Question	SCC response
1.	General		
3.1.2	Applicant and Surrey County Council (SCC)	<p>In your Statement of Common Ground (SoCG) [REP5-009] the Applicant refers to a schedule of works that are expected to become the responsibility of SCC in the future should the DCO be made. When is this schedule going to be provided to SCC? In addition, is SCC content with the two plans that the Applicant has provided and which are described in section 1.4.1 of [REP5-009]?</p>	<p>SCC are currently awaiting receipt from the Applicant of the schedule of works that are expected to become the responsibility of SCC in the future should the DCO be made. To assist the applicant SCC prepared and sent to the Applicant (on 14/02/20) a suggested draft table for use to determine the value of commuted sums to cover maintenance of additional items.</p> <p>This list was not exhaustive and needs to be added to as appropriate to clearly define the assets being considered but was provided to enable the Applicant to value the commuted sum payment. SCC were pleased to learn that the Applicant has been reviewing and assessing this table through its Commercial Team and SCC look forward to receiving confirmation of the a

Figure 1: Replacement Land locations and existing special category land

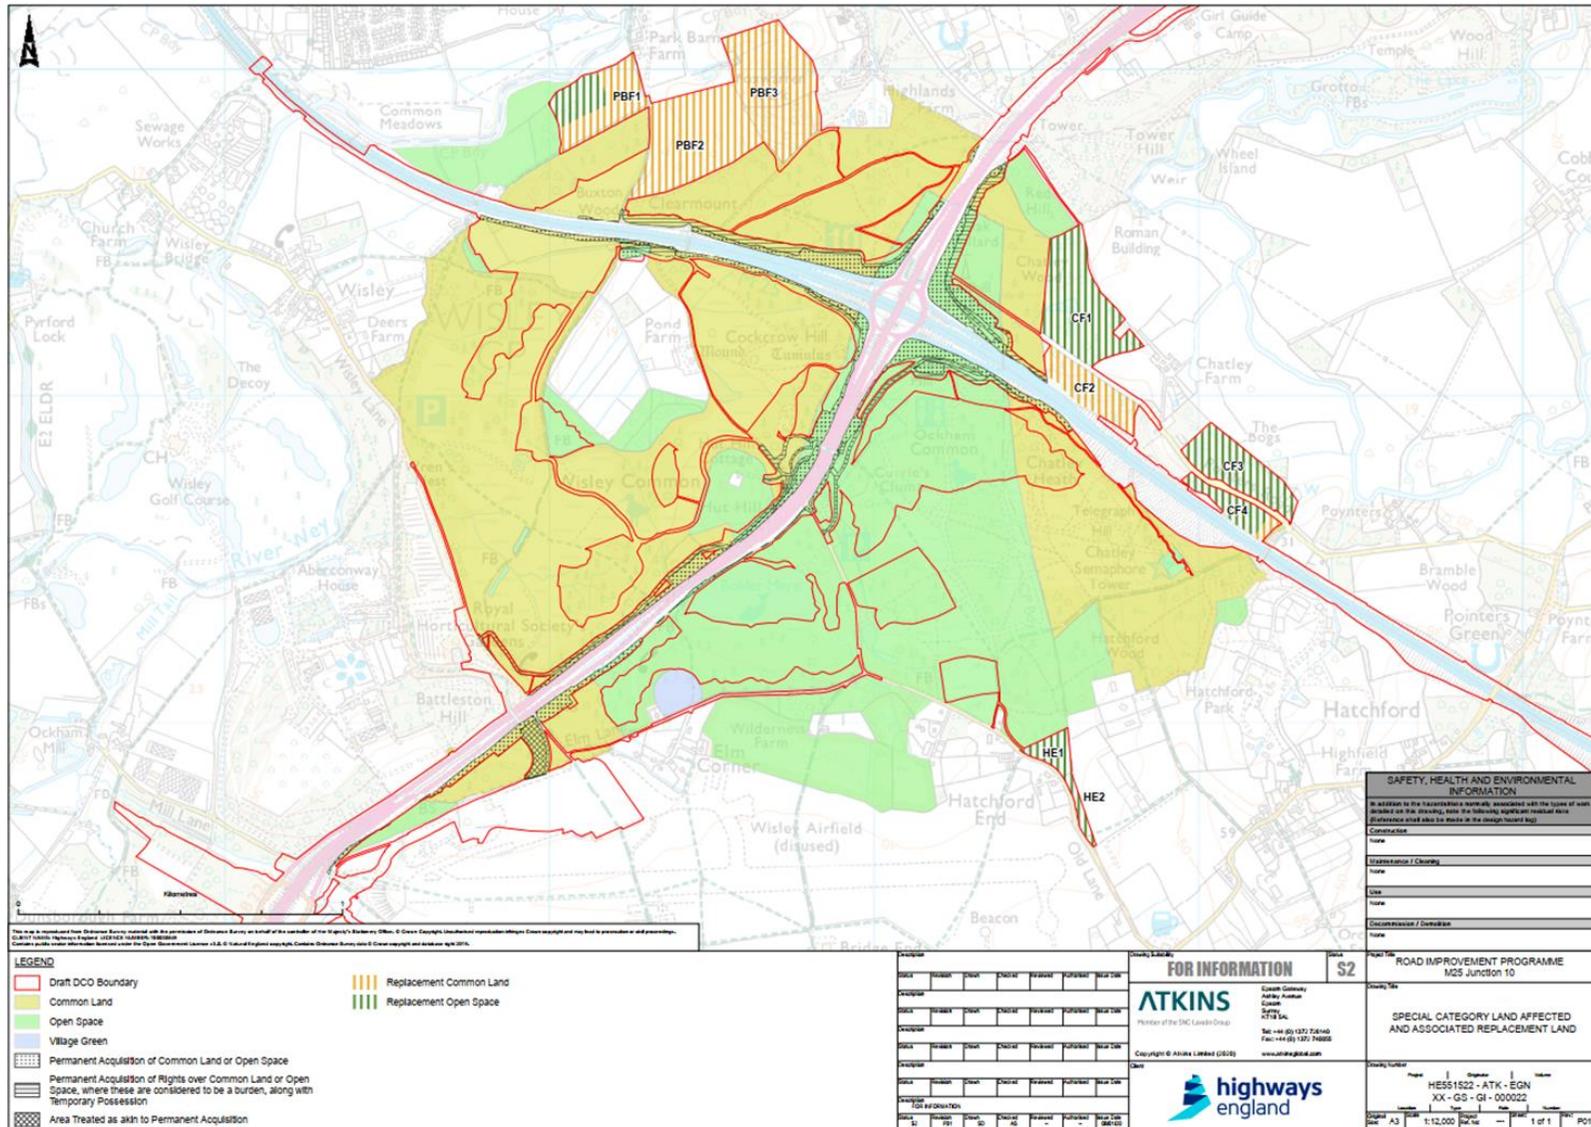
3.9.3	SCC, EBC and GBC	<p>With respect to the proposed provision of replacement land in exchange for SCL and the range of possible options outlined in Table 1 of the 'Note on Implications of Potential Reduction in Replacement Land' [REP5a-012], please:</p> <p>a) identify the three SCL options in Table 1 that you most and least favour, ranked in order of most/least preferred; and</p> <p>b) explain the reasons for those choices.</p>	<p>SCC most favours the options for possible reduction from most to least to least favourable ;</p> <p>5 -small woodland area not contiguous with SCL</p> <p>6- small woodland by M25 and limited connectivity</p> <p>7- very small area at extremity of site</p> <p>SCC least favours the options for possible reduction from most to least favourable</p> <p>3- largest area with good connectivity with SCL</p> <p>2- second largest area with good connectivity with SCL</p> <p>3- smaller wetter area of grassland, less attractive for public access and part may be used for Sanway FAS.</p>

Figure 3-1 Layout of south-facing slips at Ockham as proposed by RHS

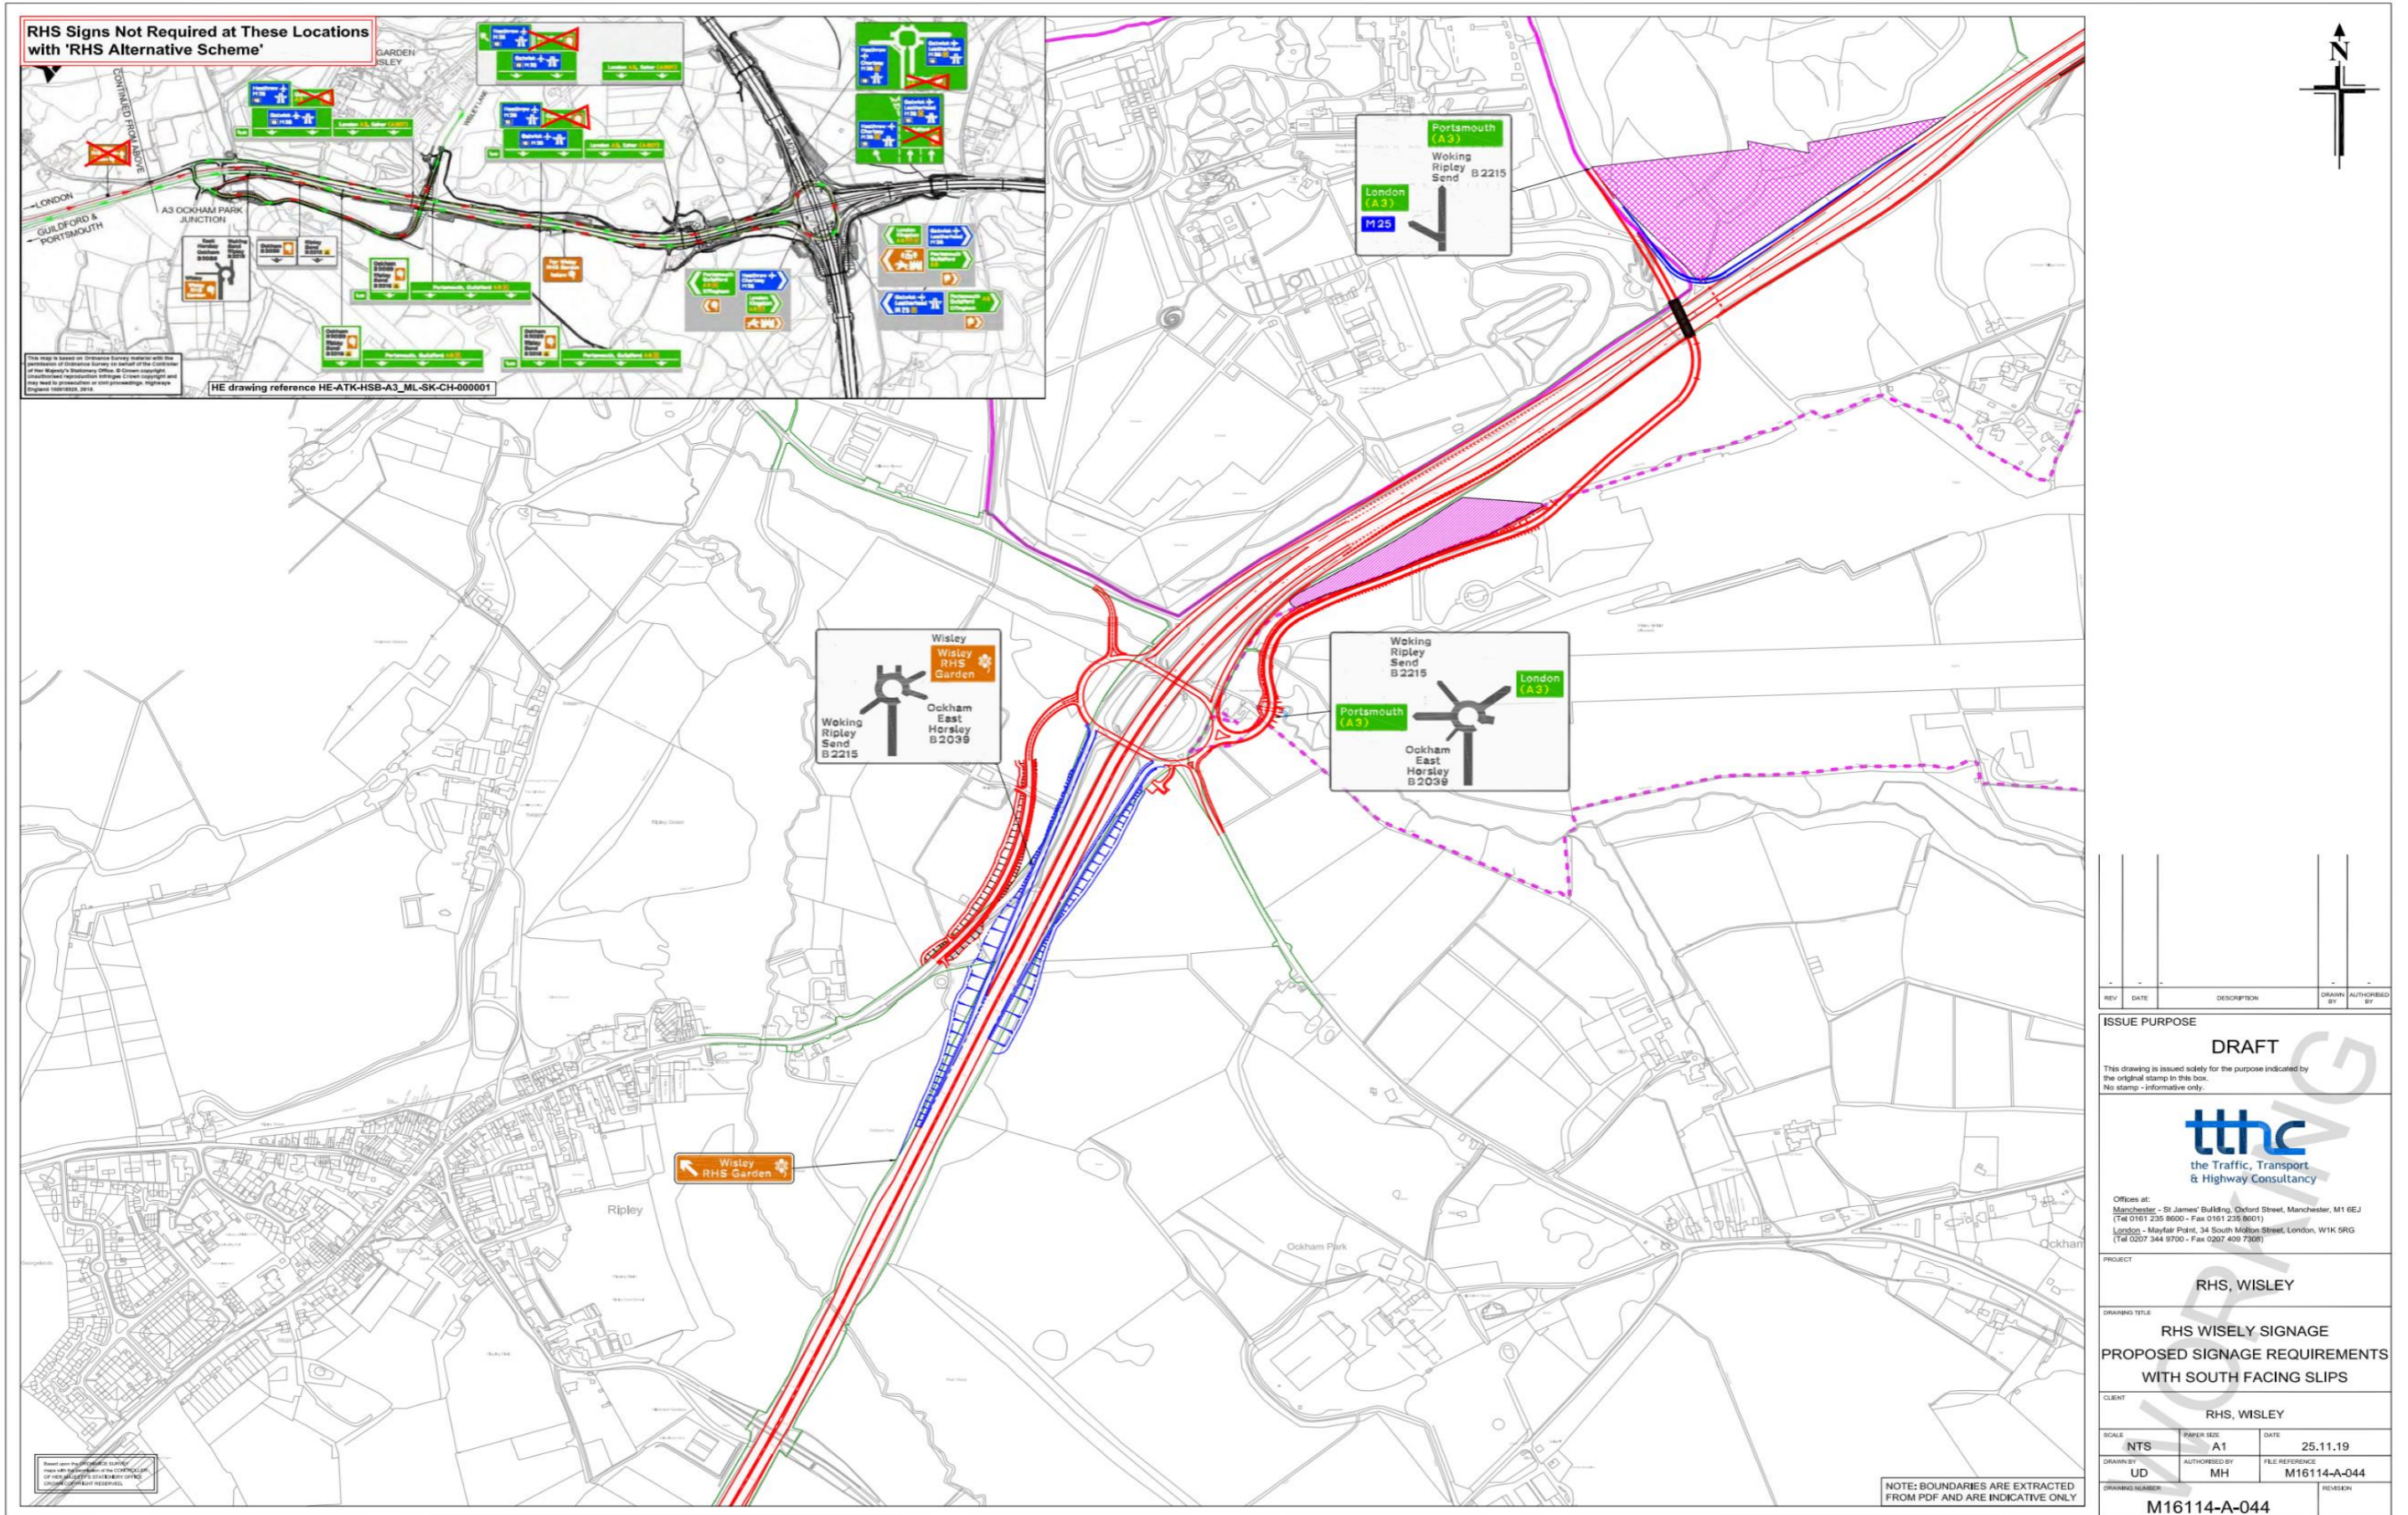
3.13.2	Applicant and SCC	<p>While the ExA is aware that the Proposed Development does not and will not include south facing slips at the Ockham Park Junction, the ExA considers that in order for it to understand what the hypothetical effect the availability of south facing slips would have on the predicted distribution of traffic on the strategic and local road networks within the vicinity of Ripley, that the Applicant and/or SCC should extend the traffic modelling that has already been undertaken to date to include model runs that incorporate south facing slips at the Ockham Park junction.</p> <p>In this regard the ExA considers a collaborative approach is necessary and that it is for the Applicant and SCC to decide between themselves which organisation is best placed to undertake the modelling that the ExA is requiring to be undertaken. Should the Applicant and SCC be unable to agree which organisation should take the lead on which one undertakes this modelling then it will be for both the Applicant and SCC to undertake this modelling.</p>	<p>It has been agreed with HE that the Applicant will undertake the traffic modelling of south-facing slips at Ockham Park junction. SCC understand that full reporting of the results of this traffic modelling will be provided at Deadline 8, since there is insufficient time to complete the modelling and fully report on the results by Deadline 7. Nonetheless, the following initial conclusions have been made by HE from the spreadsheet modelling undertaken to date, the assumptions made and the currently available outputs have been set out as follows:</p> <ol style="list-style-type: none"> 1. All Wisley Lane traffic, including RHS traffic, to and from the A3 south would utilise the south-facing slips instead of routing through Ripley on the B2215. 2. All Wisley Airfield development generated traffic arriving from the A3 south in 2037 would utilise the south-facing off-slip (northbound) to access the proposed development via Ockham Park junction, rather than route through Ripley on the B2215. 3. All Wisley Airfield development generated traffic heading for the A3 south in 2037 would utilise the south-facing on-slip (southbound) via Ockham Park junction when leaving the development site, rather than use Old Lane as indicated by the 2037 DCO Scheme Do-something traffic modelling. 4. Traffic flows along the B2215 through Ripley with the DCO Scheme plus south-facing slips at Ockham Park junction would be effectively unchanged compared to the Do-minimum scenarios. 5. With the DCO Scheme plus south-facing slips there is a significant reduction in the forecast increase in traffic on Old Lane between the Wisley Airfield site access and the A3 as a result of the rerouting of Wisley Airfield generated traffic heading for the A3 southbound via Old Lane to instead utilising the south-facing on-slip (southbound) via Ockham Park junction.

<p>6. It is not known what the impact of the slips might be on other movements that presently or in the future would travel through villages such as Ockham, Effingham, East and West Horsley and Pyrford.</p> <p>7. With the DCO scheme and south facing slips at Ockham Park interchange it is forecast that in 2022 up to approximately 900 vehicles per day would use the off-slip and 700 vehicles per day would use the on-slip road , with less than 85 vehicles per hour using each slip road in any peak hour.</p> <p>8. With the DCO scheme and south facing slips at Ockham Park interchange it is forecast that in 2037 this increases to approximately 2,750 vehicles per day utilising both the off and on slip roads, mostly due to traffic generated by the Wisley Airfield development, with between 150 and 350 vehicles per hour using each slip road in any peak hour.</p> <p>However, SCC do have some further questions and comments on the above, as follows:</p> <ol style="list-style-type: none"> 1. It is unclear what modelling HE are referring to when they state that 'Final reporting of the results of this traffic modelling will be provided at Deadline 8': is it the spreadsheet model or modelling using HE's strategic model? SCC assume the outputs available are based on the former, but it is suggested this is clarified. However, if the full reporting is to be based on other modelling then this should be explained as the outputs will change. 2. The outputs are reported are very much based on the assumptions made. For example, output (3) states that all Wisley Airfield traffic heading for the A3 south would utilise the A3 s/b on-slip as opposed to using Old Lane. However, in reality, it is likely to be only a proportion of these trips, albeit potentially the majority that would utilise

<p>the new on-slip as other trips might still find the use of the Old Lane junction to access the s/b A3 more convenient depending upon their origin within the development. Consequently, it is the assumptions made driving the outputs rather than the modelling: the spreadsheet model is more a means of displaying these assumptions and the resulting change in flows rather than anything more complex. While SCC does not disagree with this approach and concurs it is an appropriate method given the time constraints, SCC considers that more clarity might be helpful to the ExA.</p> <p>As a simplified approach is being taken to the modelling of the Ockham slips, it is worth noting that should it be deemed useful to model the Ockham slips in conjunction with the additional Burnt Common slips additional assumptions would need to be made informed by some analysis of the existing models, and this would be more involved than the work conducted for the Ockham slips.</p> <p>SCC mention this as it may be helpful to the ExA in raising awareness (if not already known) that the north facing Burnt Common slip roads are now in the Road Investment Strategy 2 (RIS2) as a RIS3 Pipeline project for investigation in RIS2. SCC understand from the RIS2 document that if the study concludes they are feasible and deliverable, the slips could be implemented in the time period 2025 to 2030.</p> <p>SCC and GBC welcome the inclusion of the Burnt Common Slips in RIS2 as they form part of the Guildford Local Plan (Policy A42) and these slips, alongside traffic management measures on B2215, would help to mitigate the impact of Local Plan growth and strategic highway improvements on the village of Ripley.</p>
